E-MEMO

Name	Company	Email address
To:	Alice Dowell	Savills	dodwell@savills.com.au
CC:	Kevin Boyle	NDY	k.boyle@ndy.com
	Laurent Laberibe	NDY	l.laberibe@ndy.com
From	Mark Painter	Date	25/03/2015
		Ref:	068582-03EM
Re	BCA Non-compliance SAS, Jane Foss Russell Building, G02, 160 City Road, Darlington, NSW 2008

drawing
LEVEL 04
EXISTING PLAN

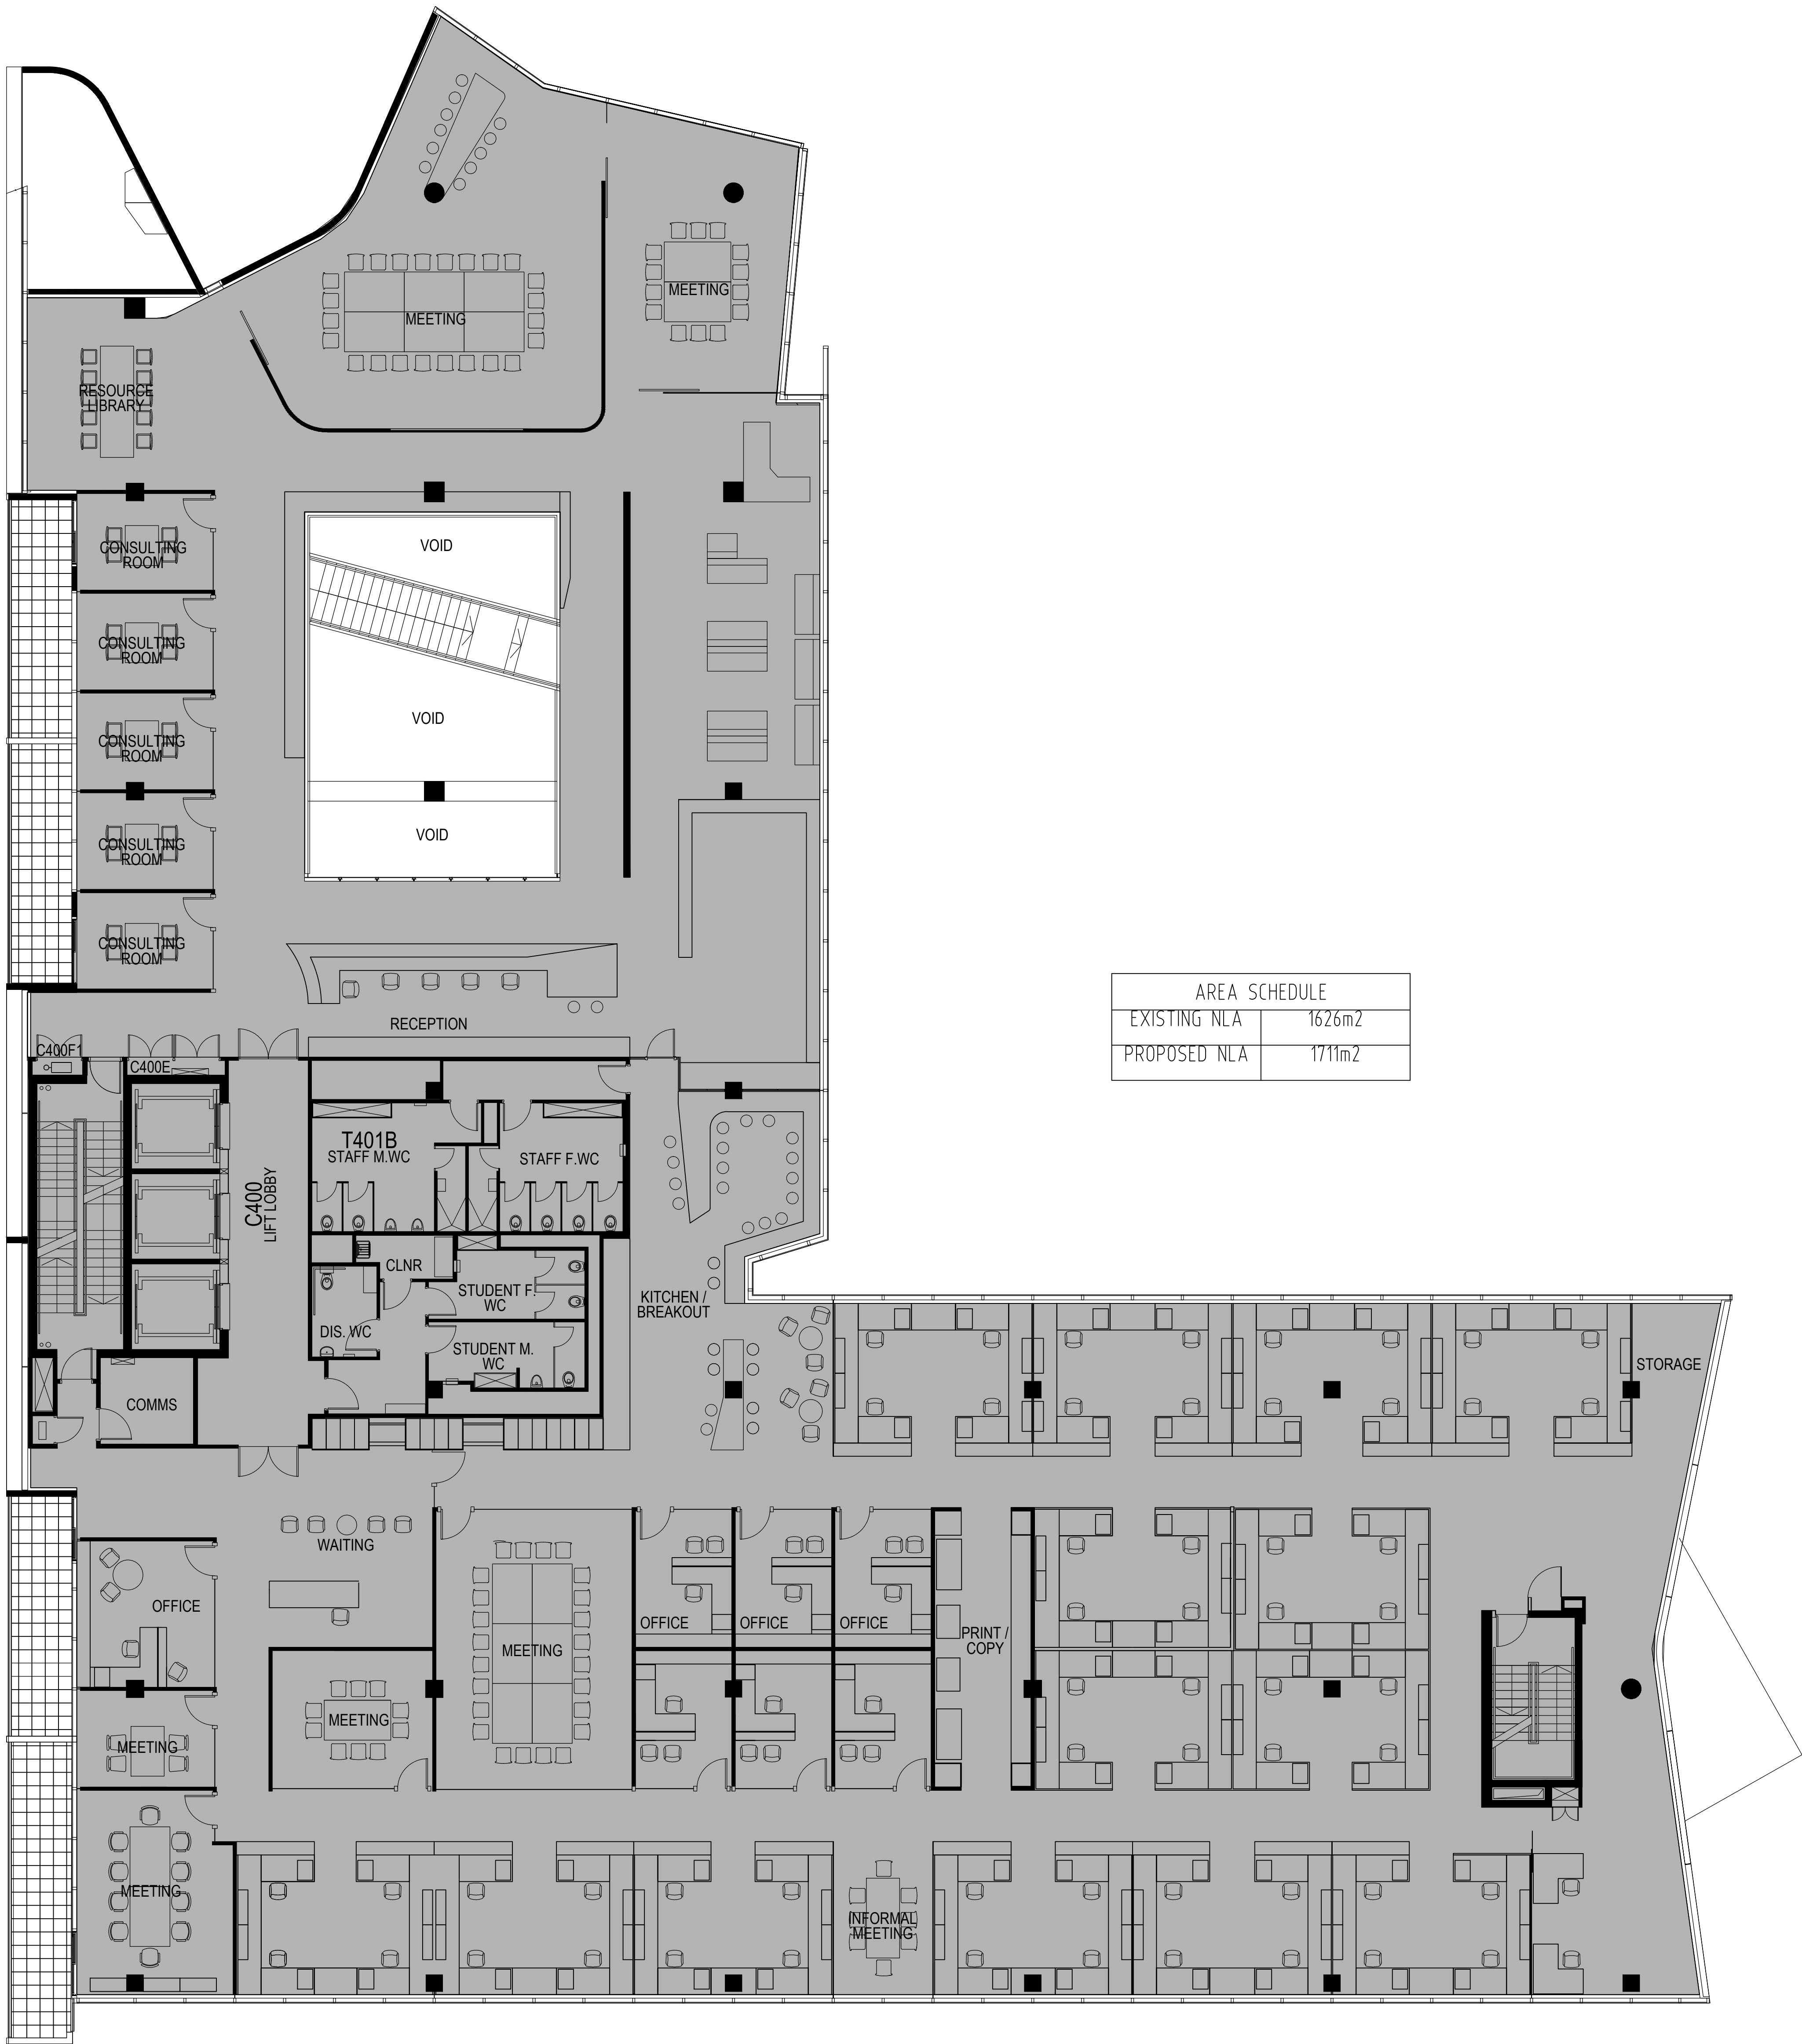
1. C2.9 Separation of classification in different storeys. Floor between level 3 & 4, which at present is an open egress staircase, is to be in filled to comply with the BCA under specification C1.1 Table 3. FRL 120/120/120
2. D1.4 Path of travel to the exits is extended on level 3 by 2m and 1m on level 6. Therefore the fire engineer will be required to assess the extended travel distances to Levels 3 and 6 against the Performance Requirement DP4 and EP2.2 of the BCA.

3. D2.20 Doors in a path of travel to swing in the direction of egress.
The doors that are situated beside reception and the resource library on level 4, into the kitchen break out room on level 6 both need to swing in the direction of egress. Currently they open in the wrong direction.
